# **SUBMISSIONS REPORT**

**SSD - 10831778**

Sydney Children's Hospital Stage 1/  
Children's Comprehensive Cancer  
Centre

**HEALTH ADMINISTRATION CORPORATION**

4 PROPOSED SHADOWS - JUNE 21 - 9AM
1:1500

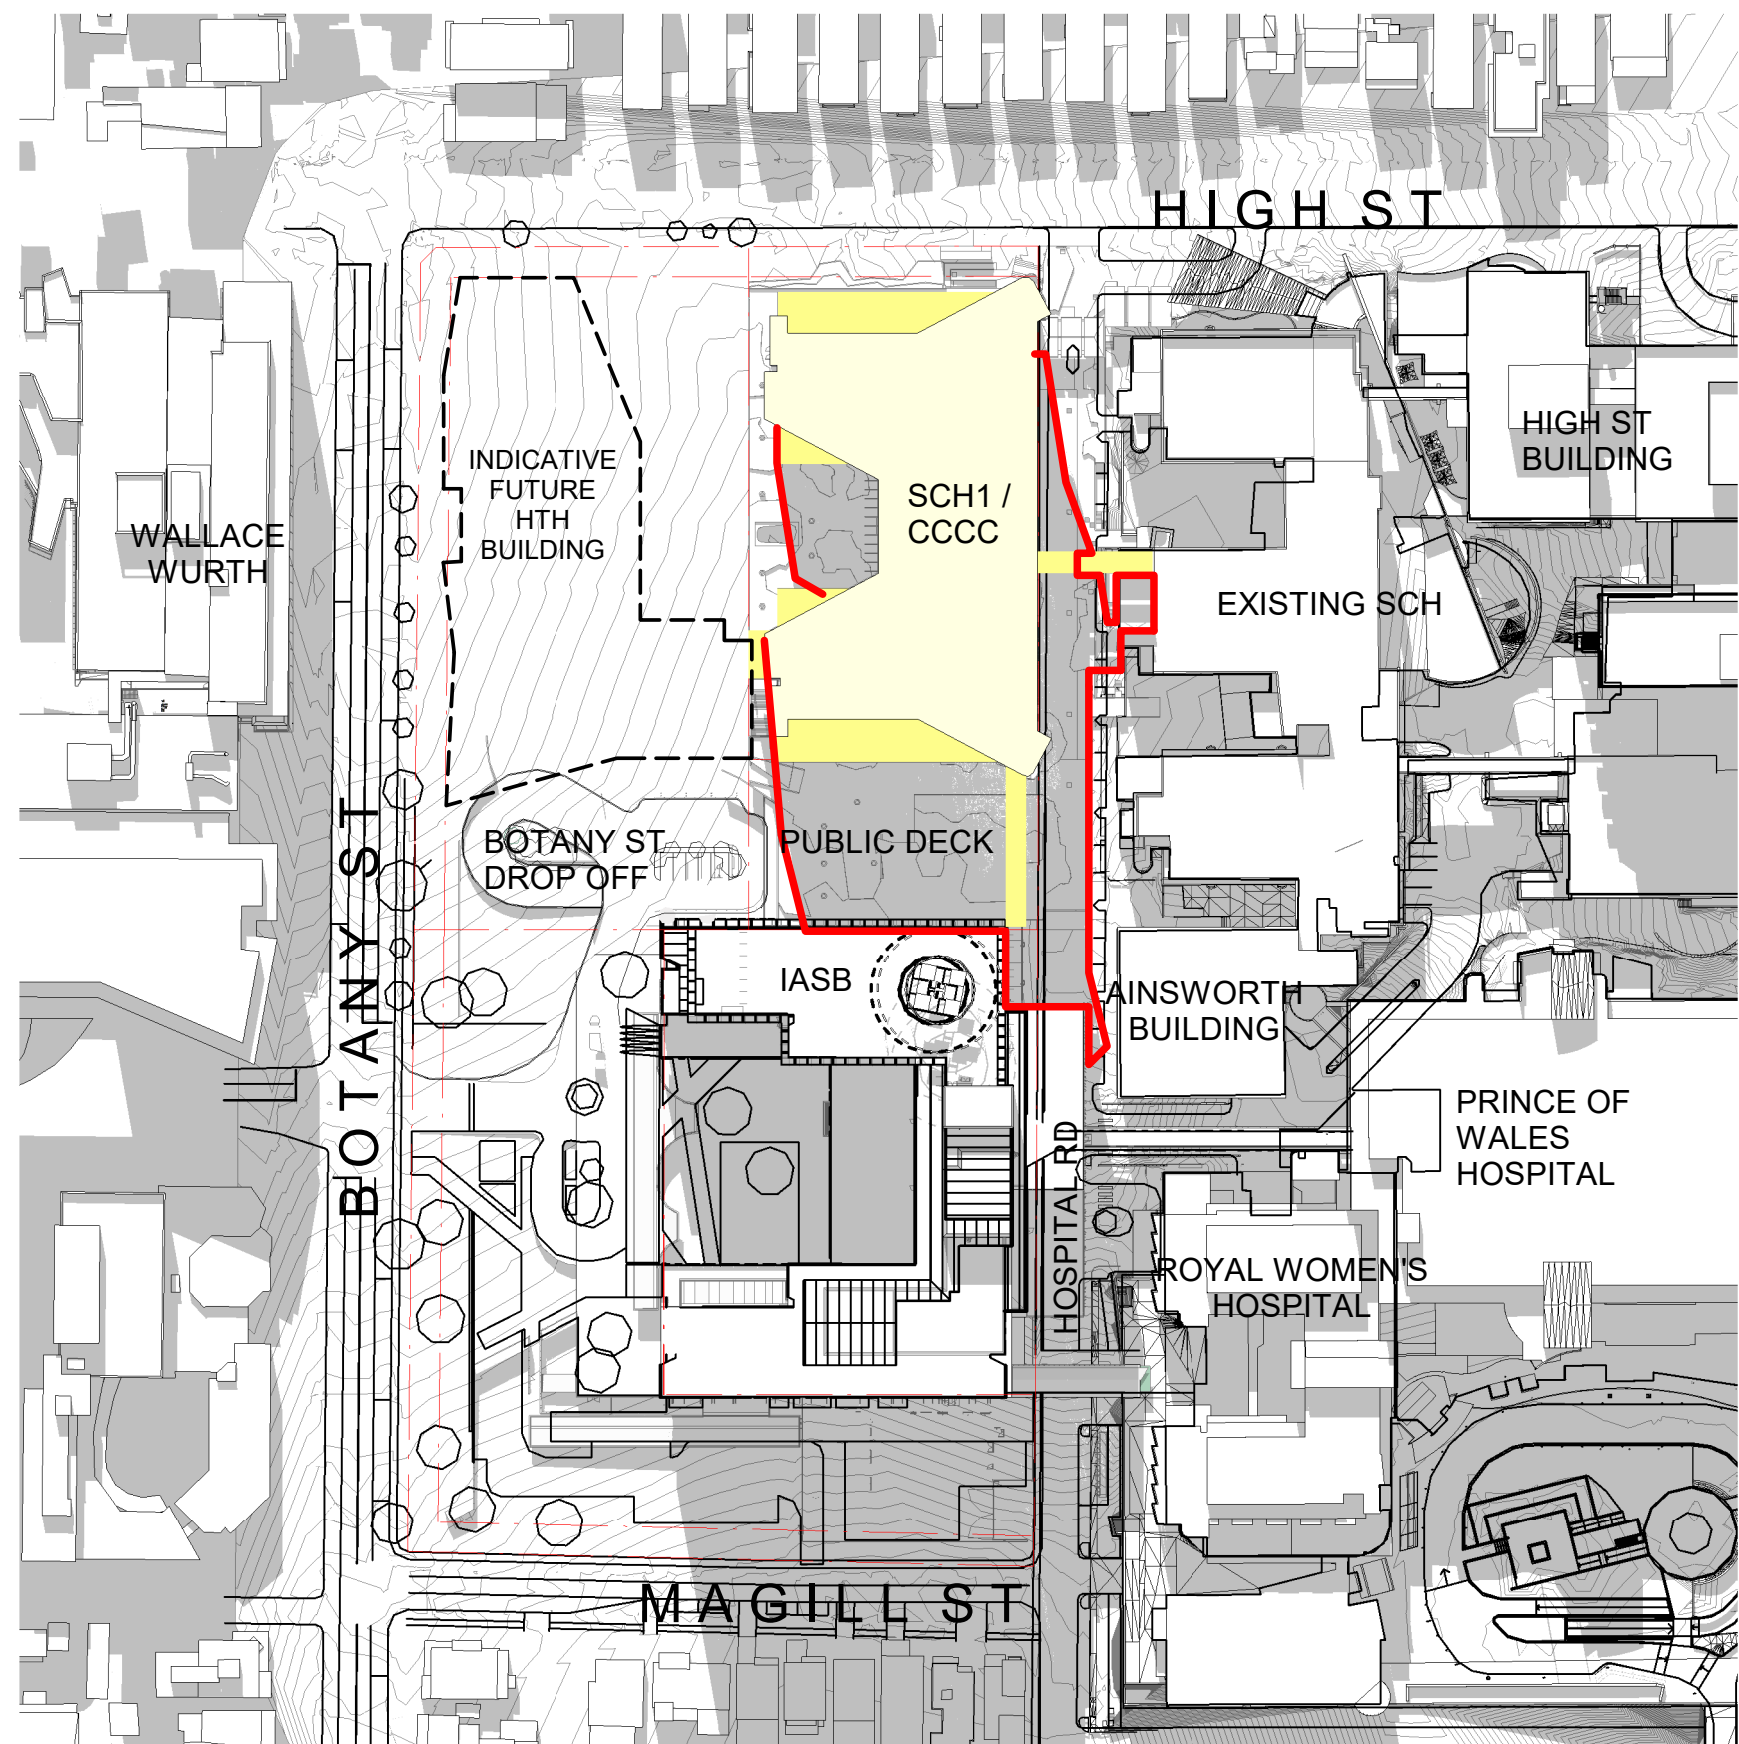
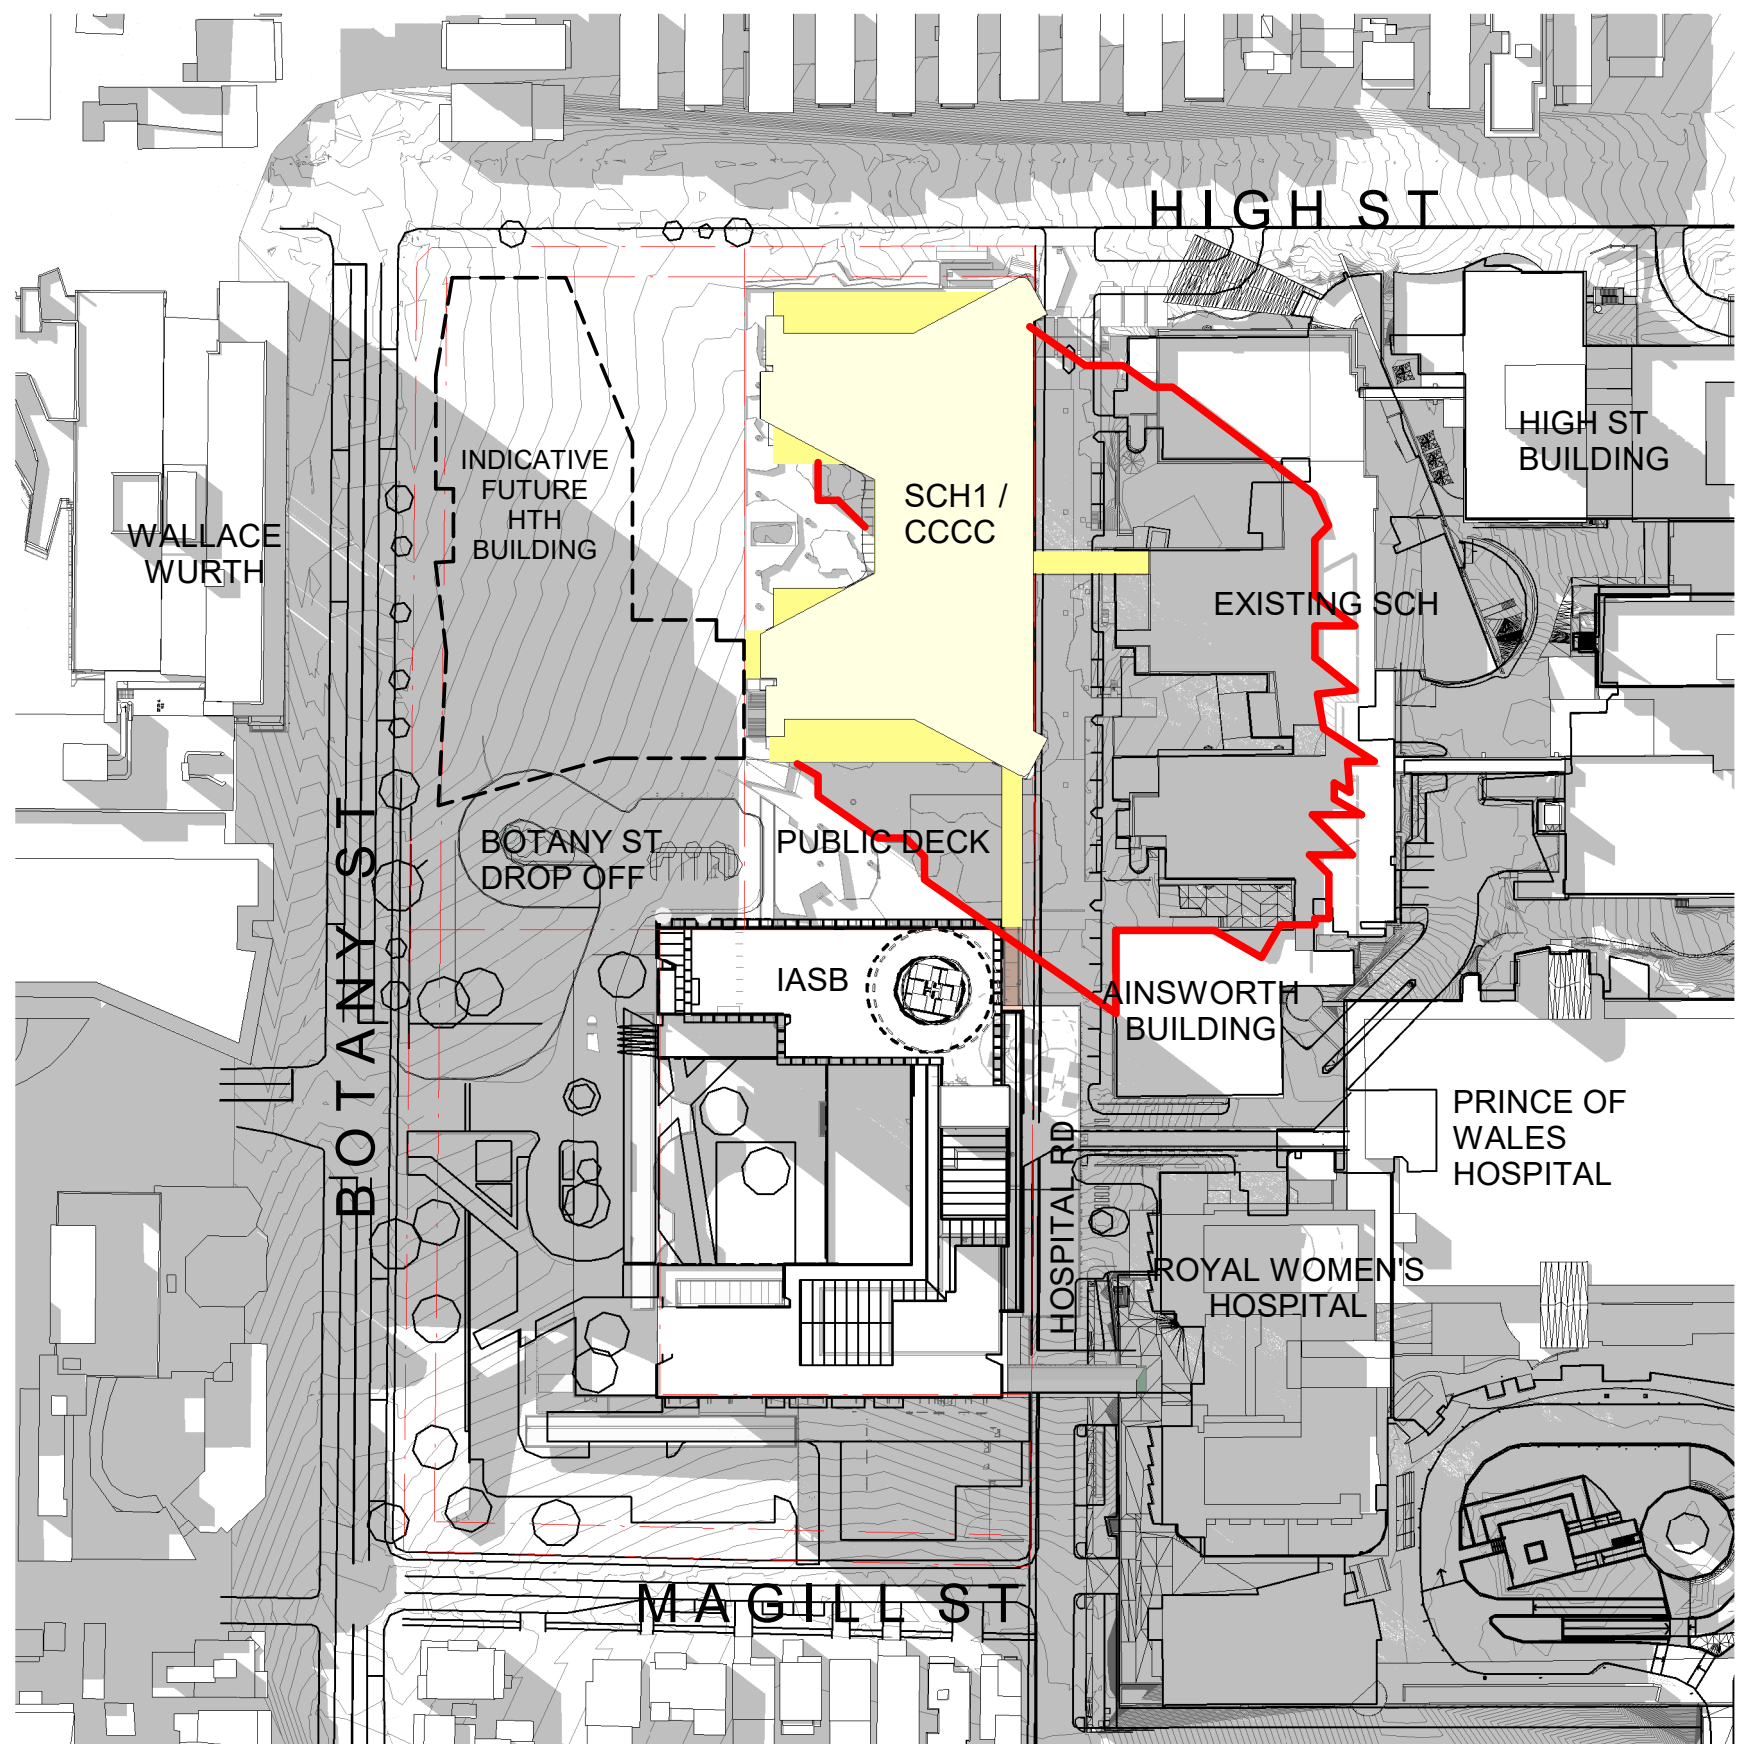
5. Amenity of Childrens' Play Area	The Department is concerned the children's play area will be heavily overshadowed and visually enclosed by surrounding built forms. The provision of an attractive outdoor space for patients of the Children's Hospital is considered an important aspect of the amenity of the building. Therefore, provide further details, visualisations and hourly solar access studies (incorporating shadowing from the proposed HTH) to demonstrate how a high level of amenity would be achieved to the proposed space. If a high level of amenity is not achieved, consideration should be given to supplementing this play space with additional attractive and safe open space for patients such as utilising the podium roof to create additional open space for patients.	<p>The children's play area in the southern podium is not the sole area available for children's play. It is supplemented with additional opportunities for informal play and discovery in both the central courtyard area, as well as along the eastern podium. These includes areas that do receive generous solar access- the northern landscaped area adjacent to High Street and the northern terrace on Level 01.</p> <p>BLP has prepared hourly shadow diagrams showing the shadows cast by SCH1/CCCC and HTH. At the winter solstice the Childrens' playground will be in shadow. However, the outdoor play space will be shaped to provide opportunities for engaging and diverse experiences to occur for ages 0-18 years, as well as families and caregivers. The design team is also working with Yerrabingin and engaging with local indigenous communities, both elders and children, to develop opportunities for this space to become meaningful and playful, and respond directly to the outcomes of the community.</p>	<b>Appendix C and Appendix D</b>
